From: Simon Davis
Sent: 19 September 2018 16:39
To: 'JGuilfoyle'
Subject: RE: AL/74/18/PL Woodgate Farm

title:	Plot 1 Elevation, 2nd Floor Plan & Roof Plan
--------	--

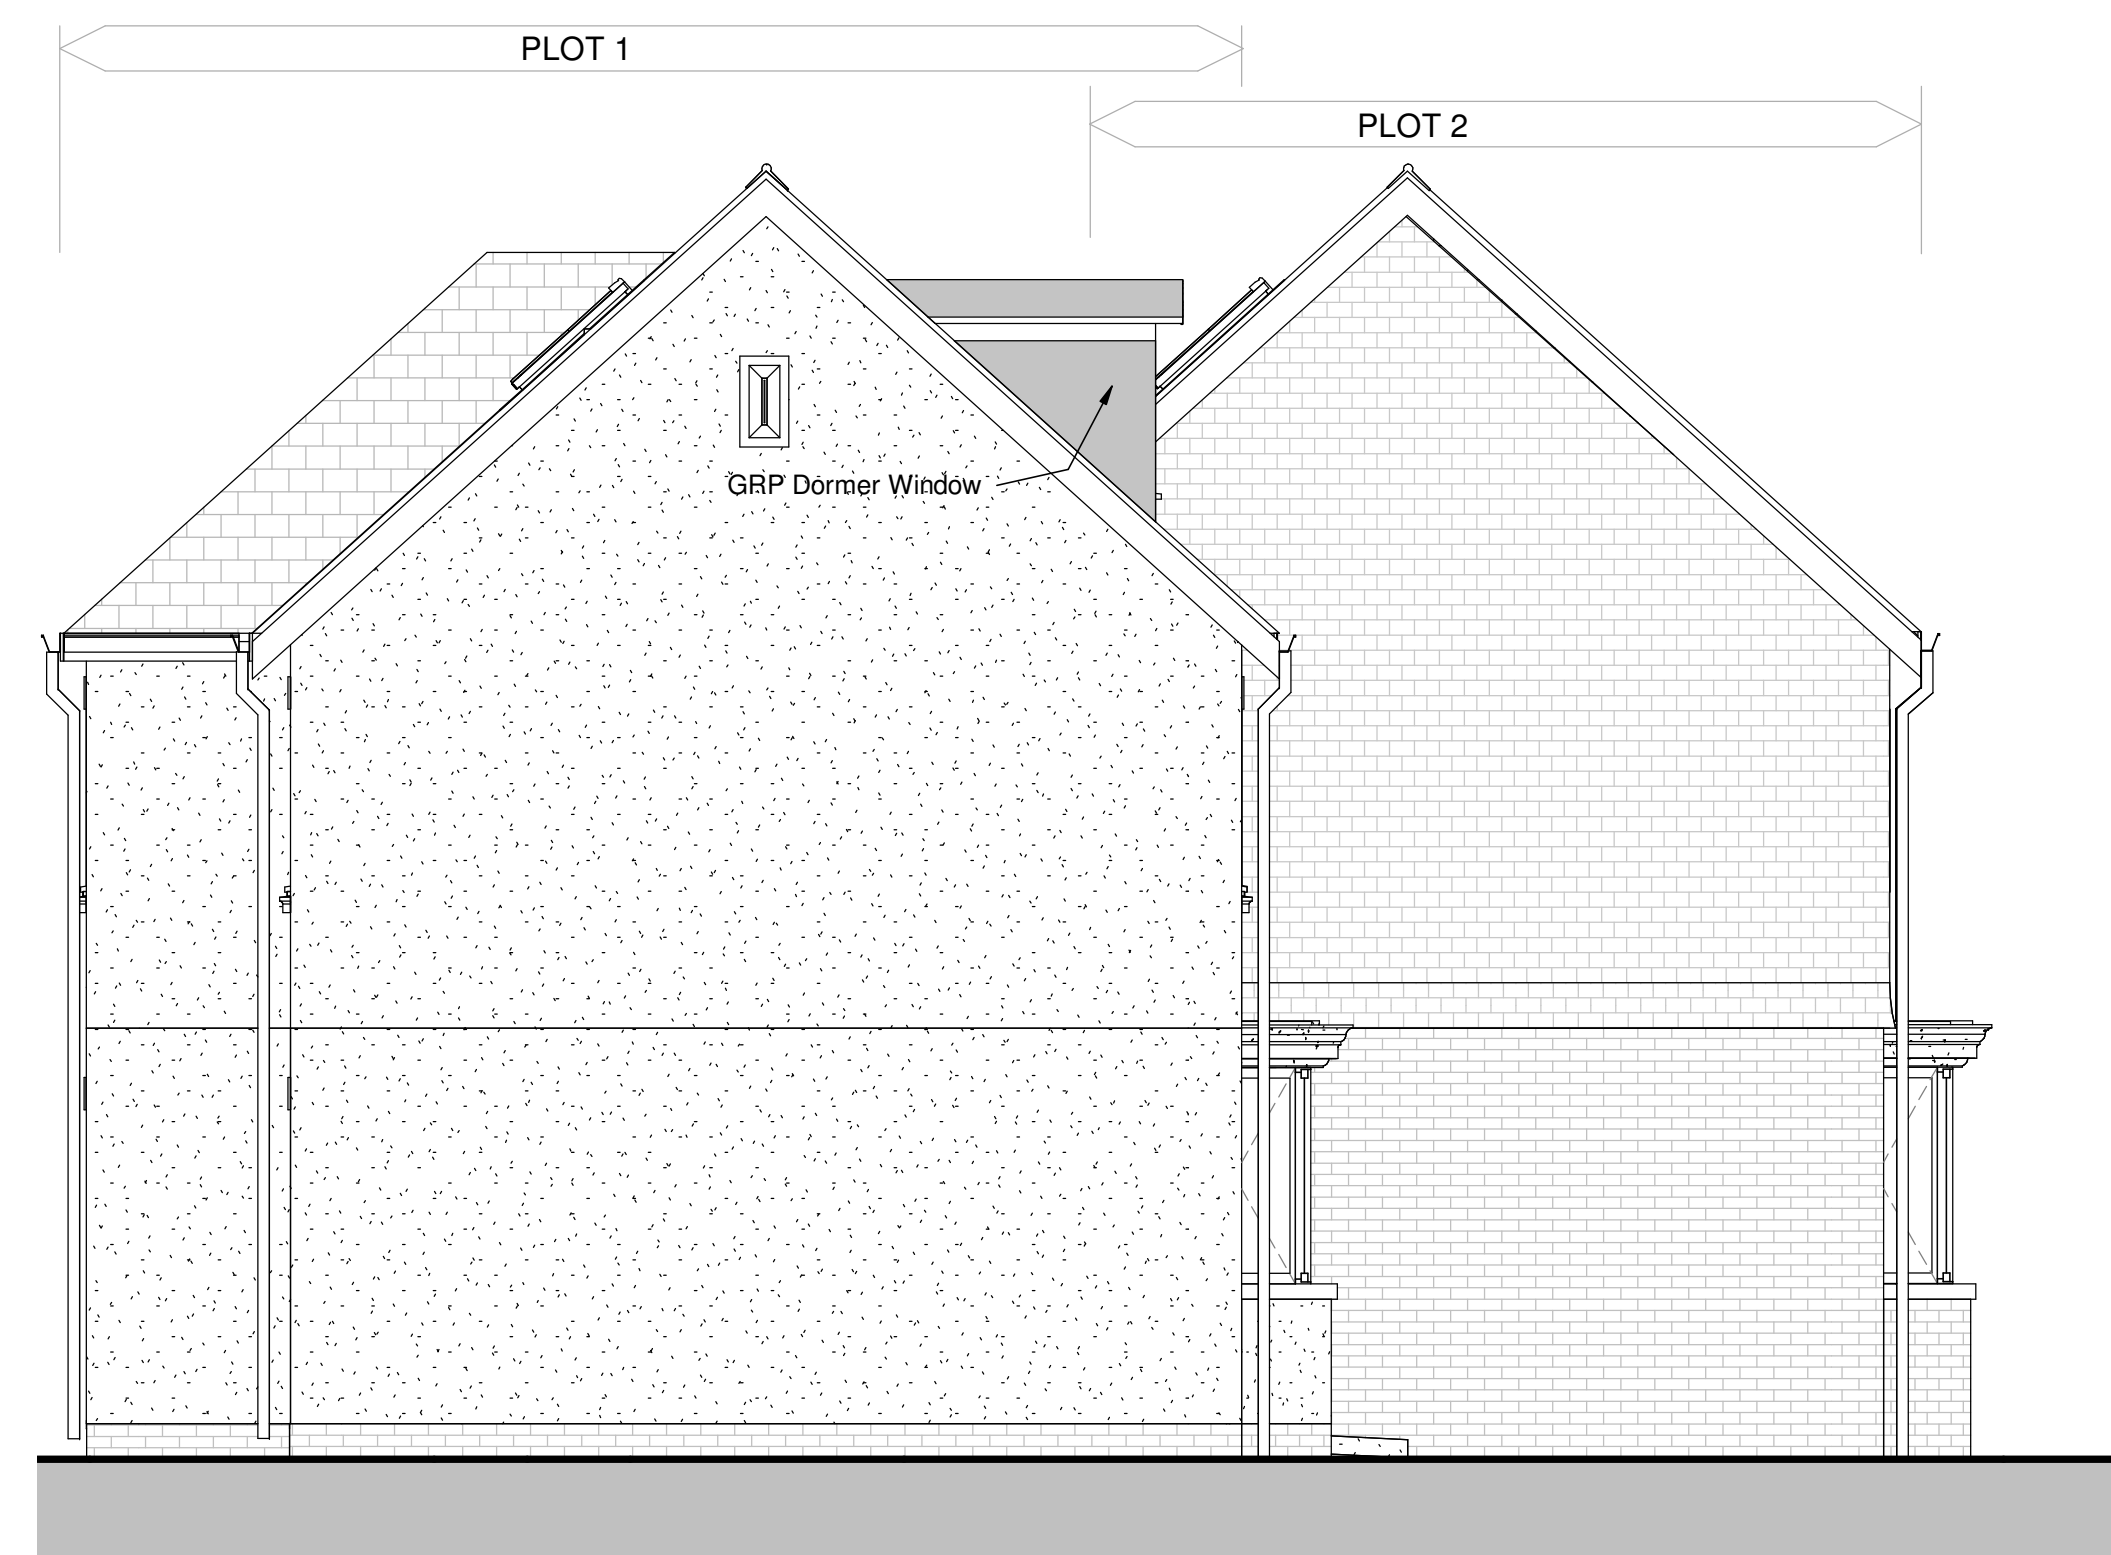
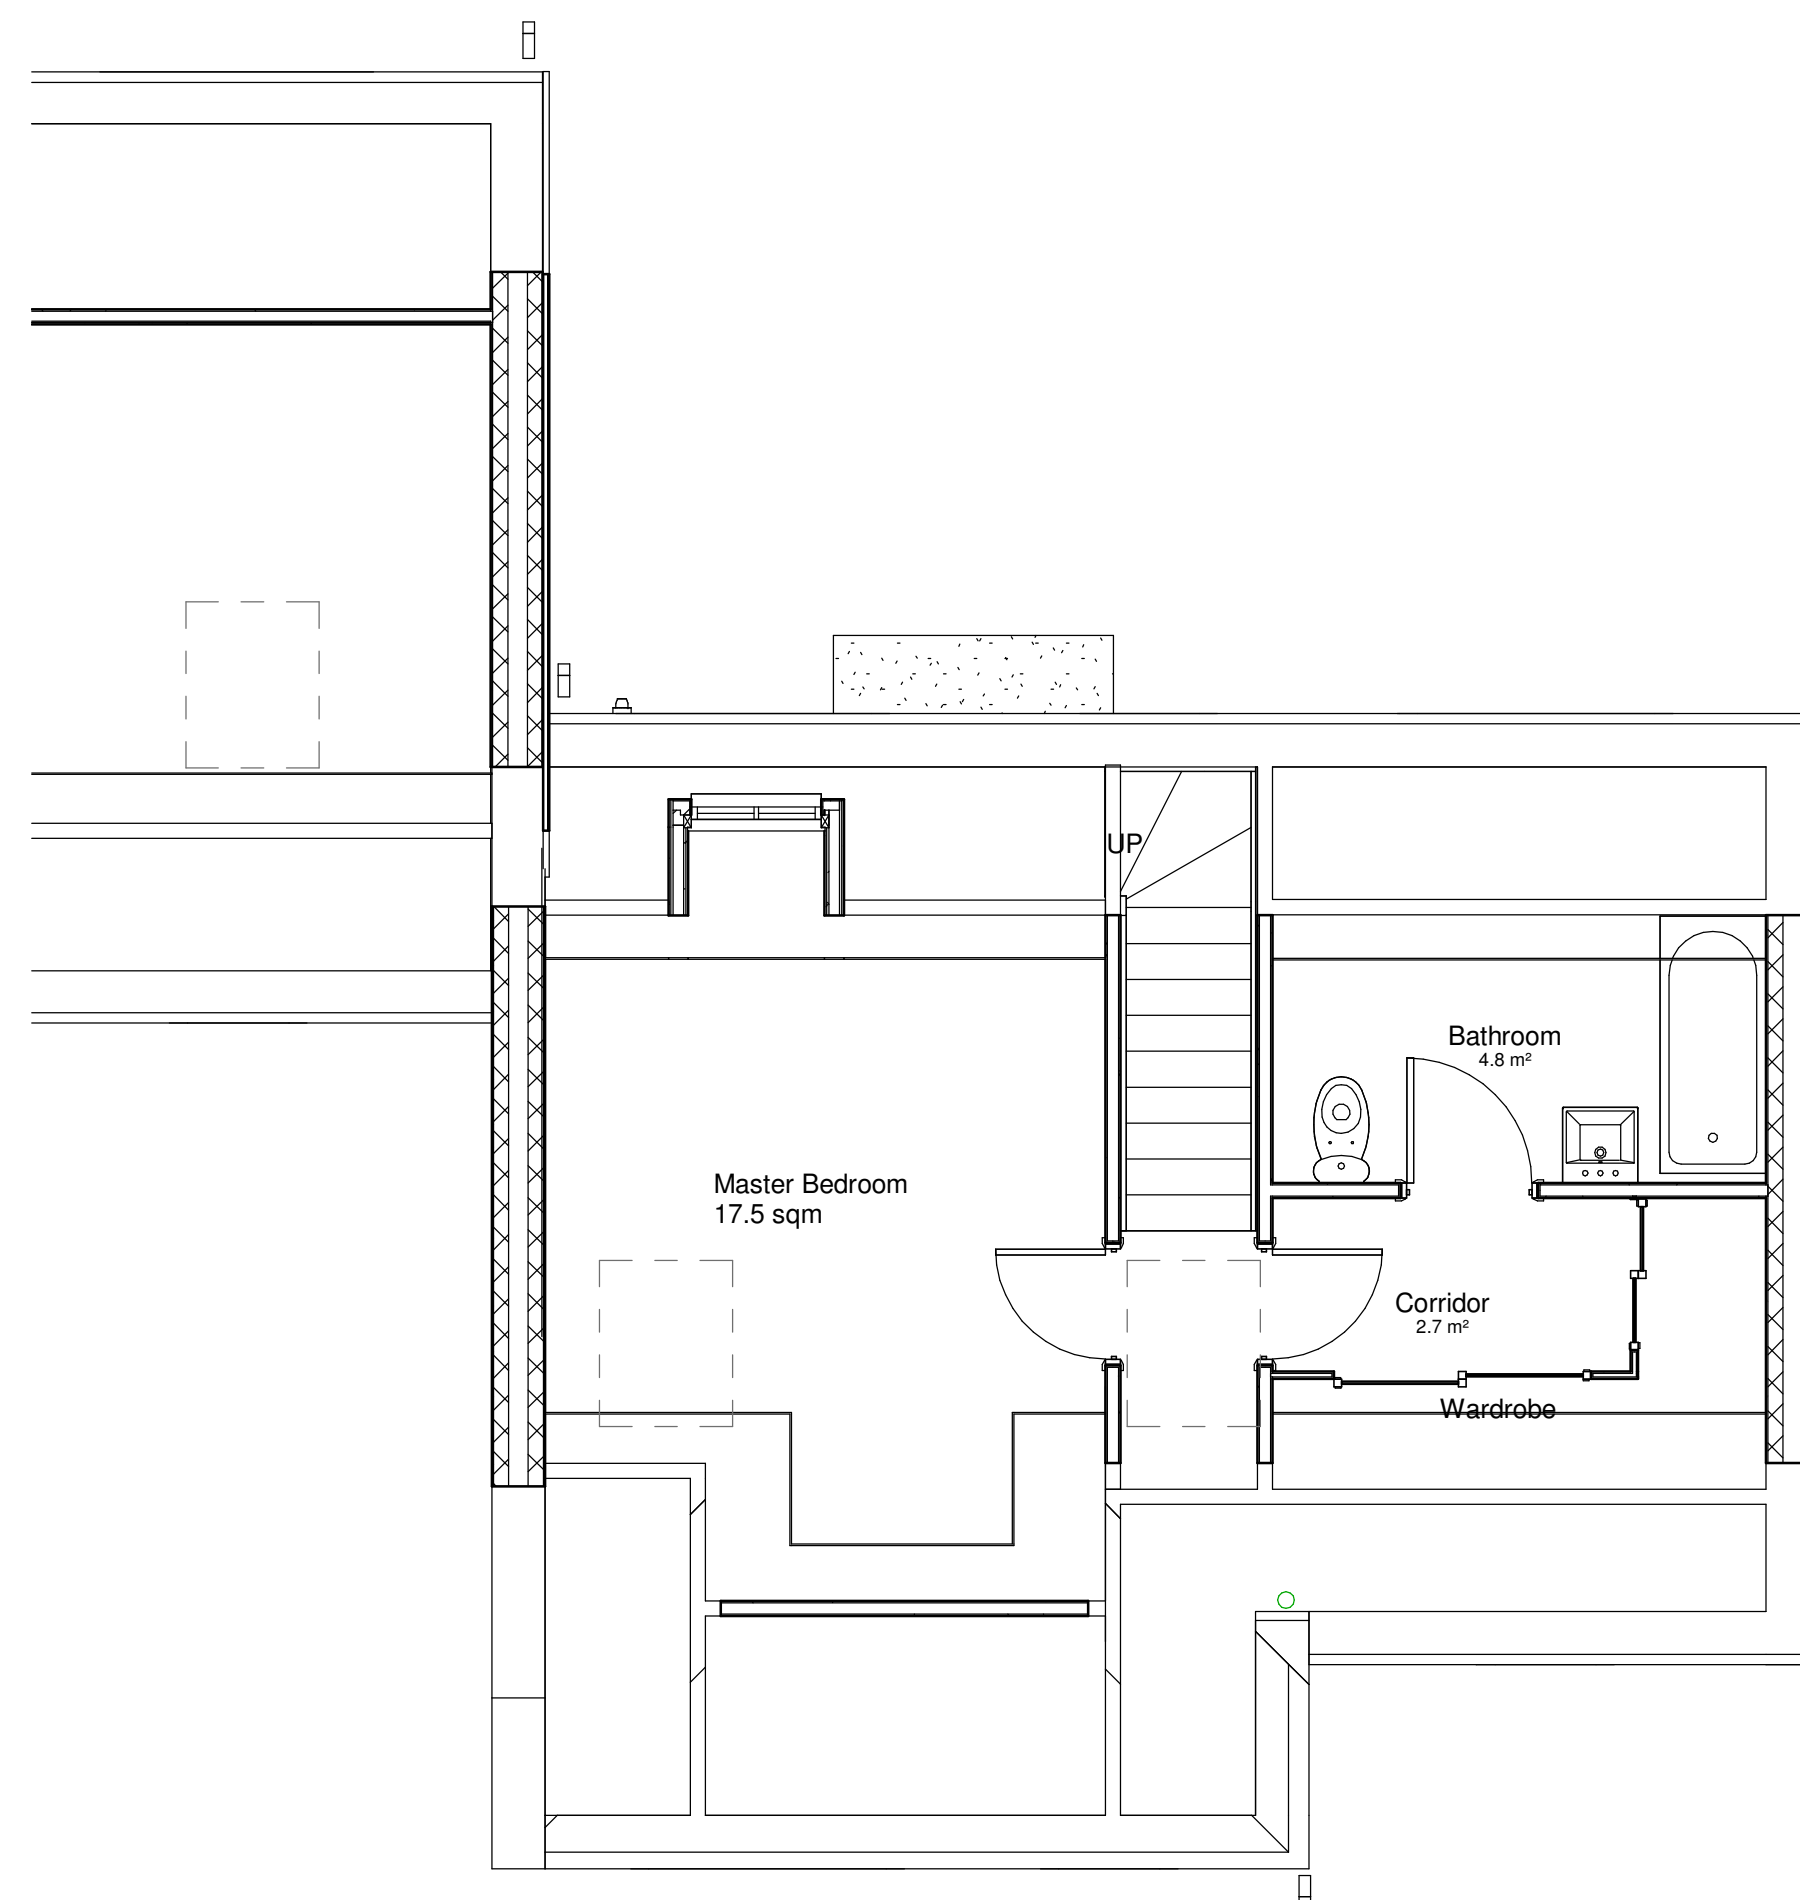
Their comment was that: "Contrary to policy H1 of the APC Neighbourhood Plan, the proposed dormer is not in keeping with surrounding properties."

Further to our conversation, I have had a look at the plans and discussed with my Team Leader. I consider that it would be difficult to argue harm associated with this small single dormer window and therefore, I will, after all, be able to support the proposal. This will need to go to Planning Committee with the next available on the 3rd October. Can you agree to an EoT until the 4th October please.
